Meridian Ranch Fieldhouse Traffic Impact Study (LSC #S234410) February 8, 2024

LSC Responses to Meridian Ranch Fieldhouse TIS Redlines 3-14-24

Figure 2
Site Plan

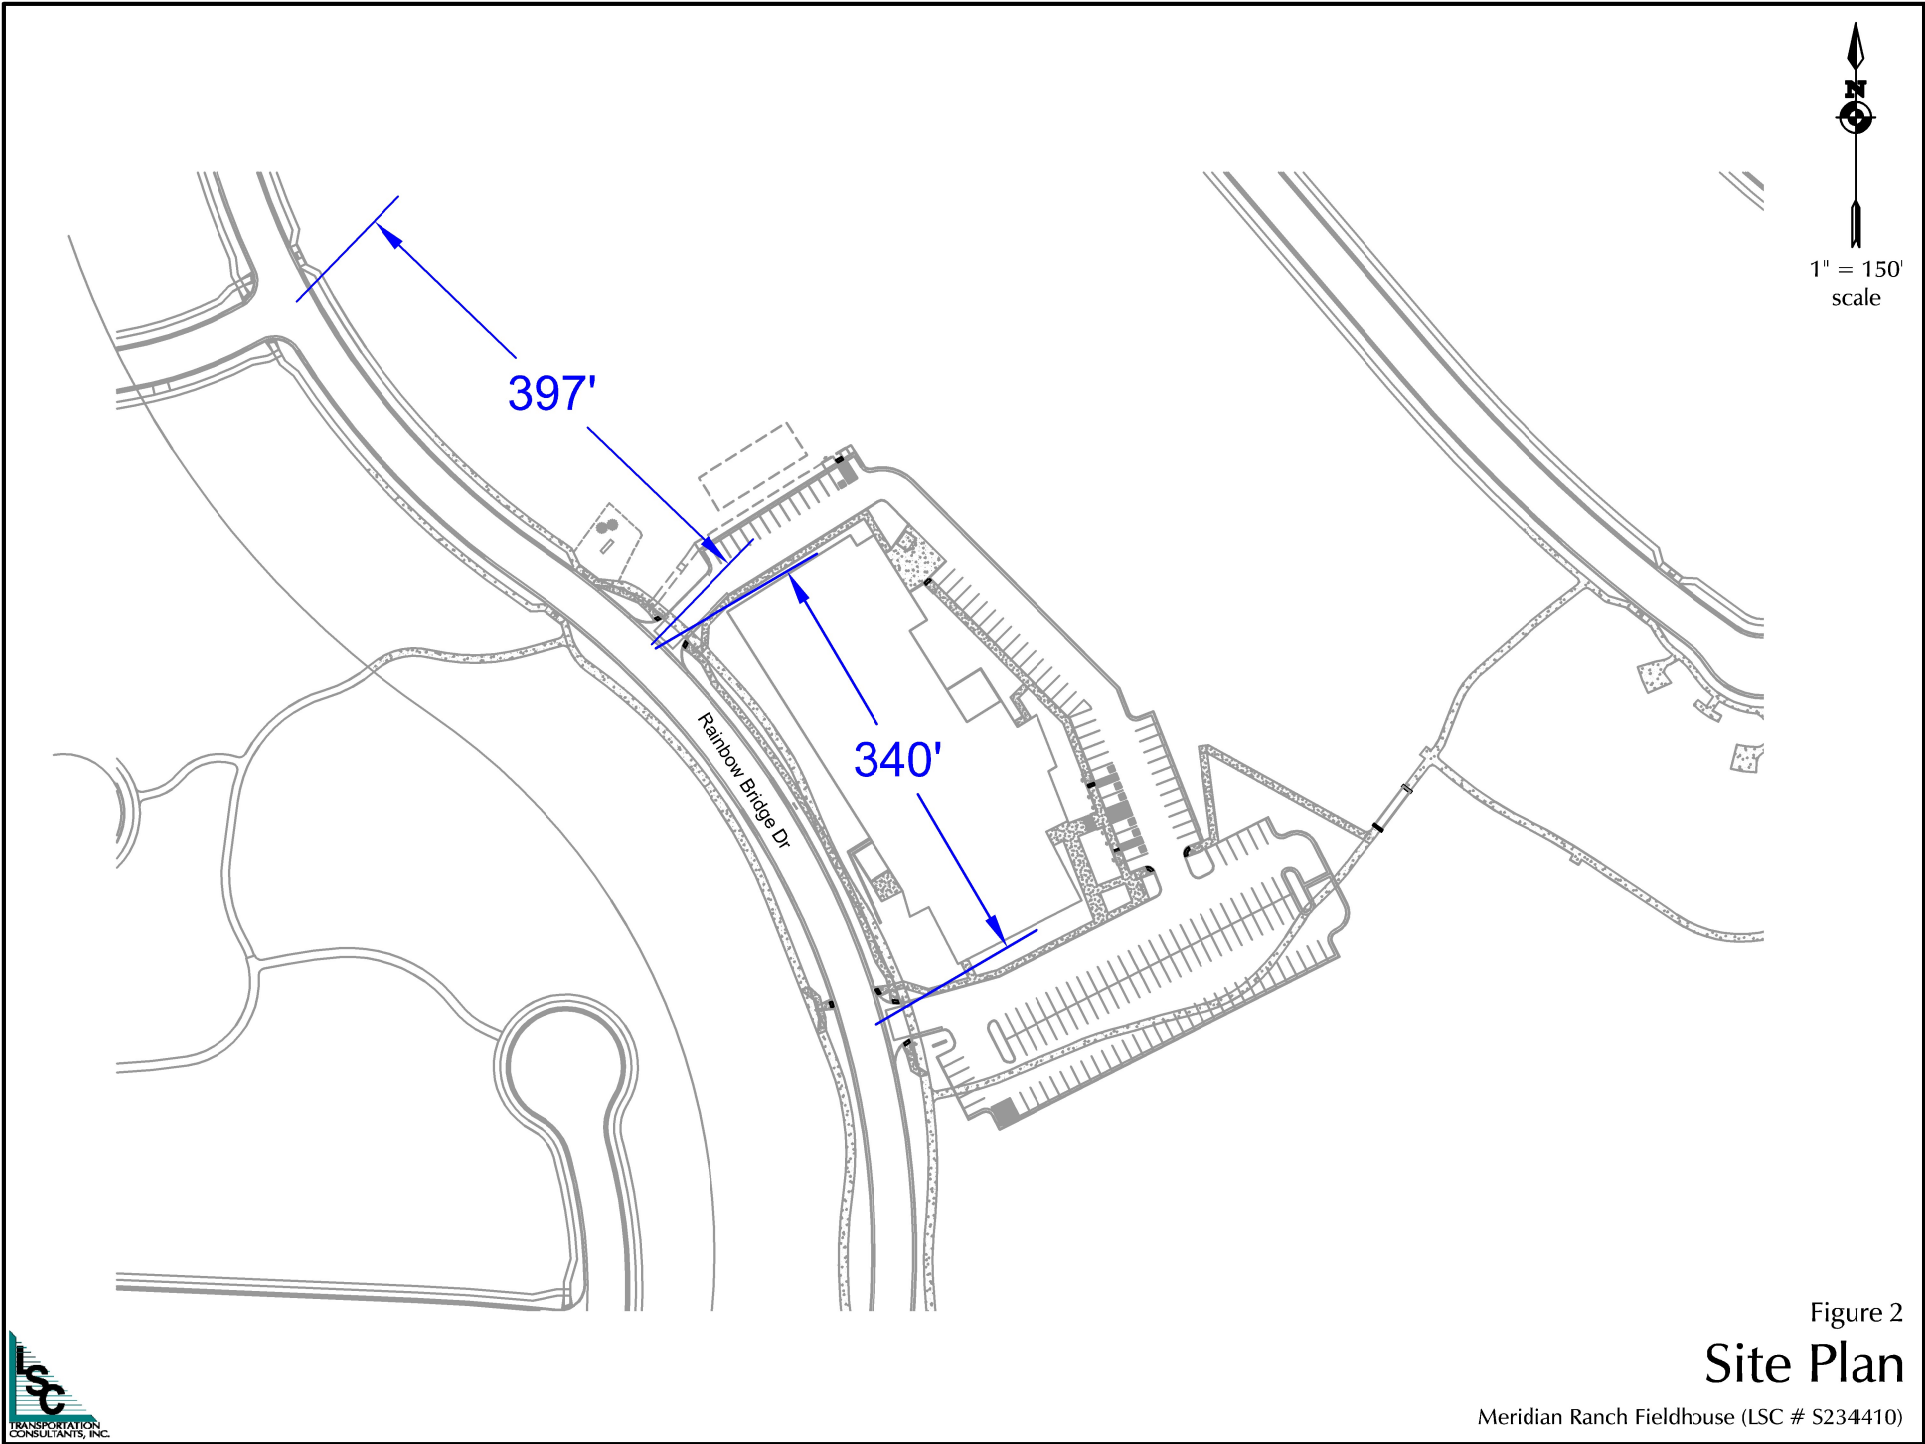
[Add discussion of school sites within 2 miles](#)

LSC Response: Per ECM Section B.2.3.B analysis of pedestrian routes within 2 miles of a school is only required for residential land uses.

We have added labels to our Figure 2 showing the area schools.

Meridian Ranch Fieldhouse (LSC # S234410)

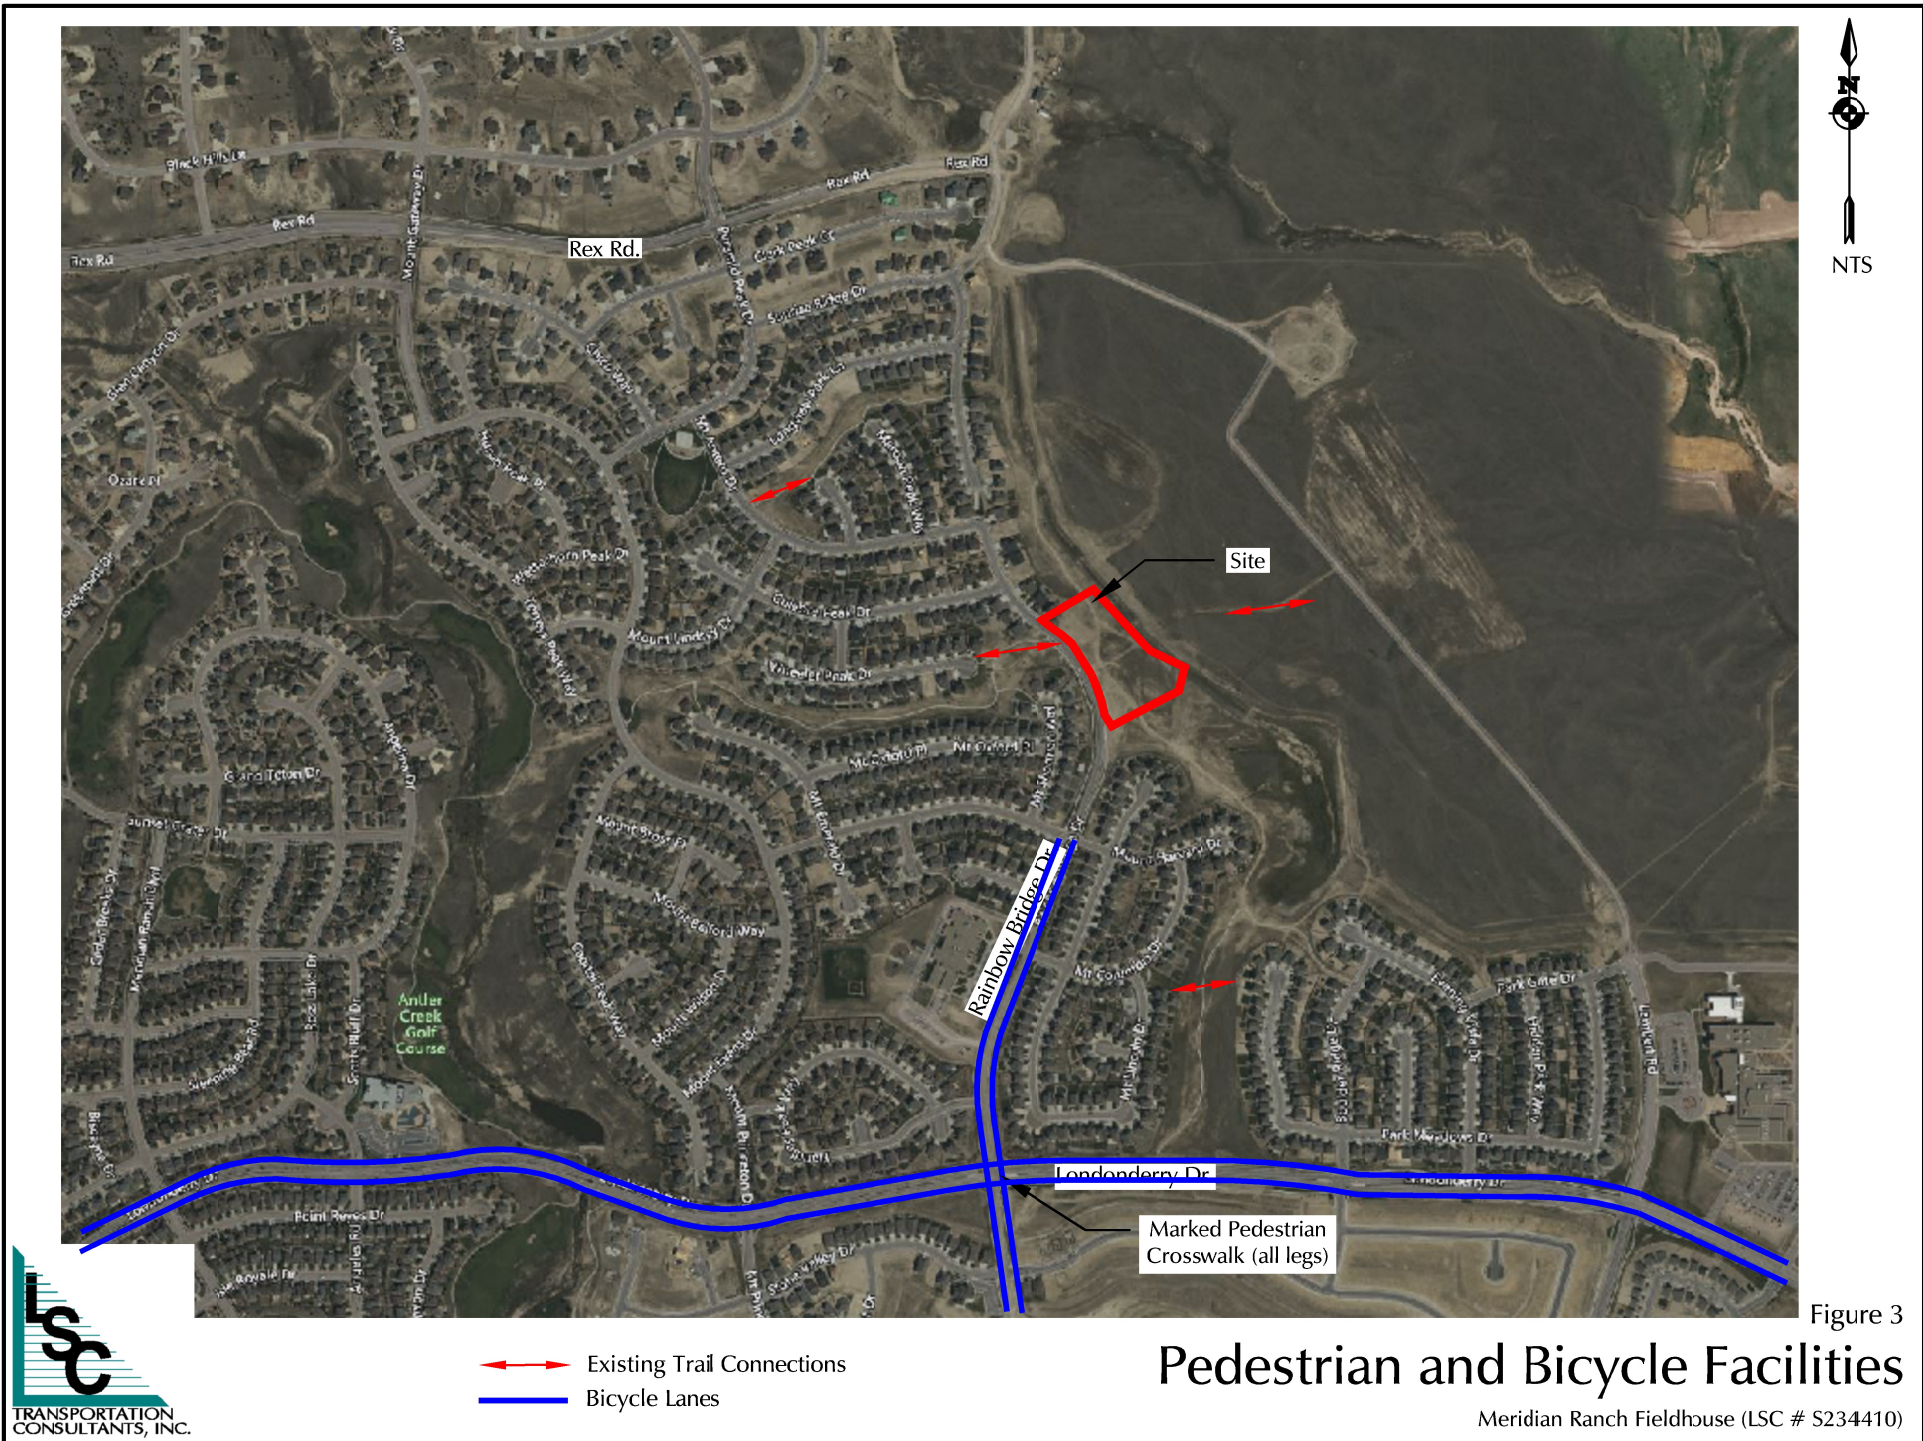
figure 3 is the pedestrian and bicycle facilities figure. revise accordingly

LSC Response: Revised as requested
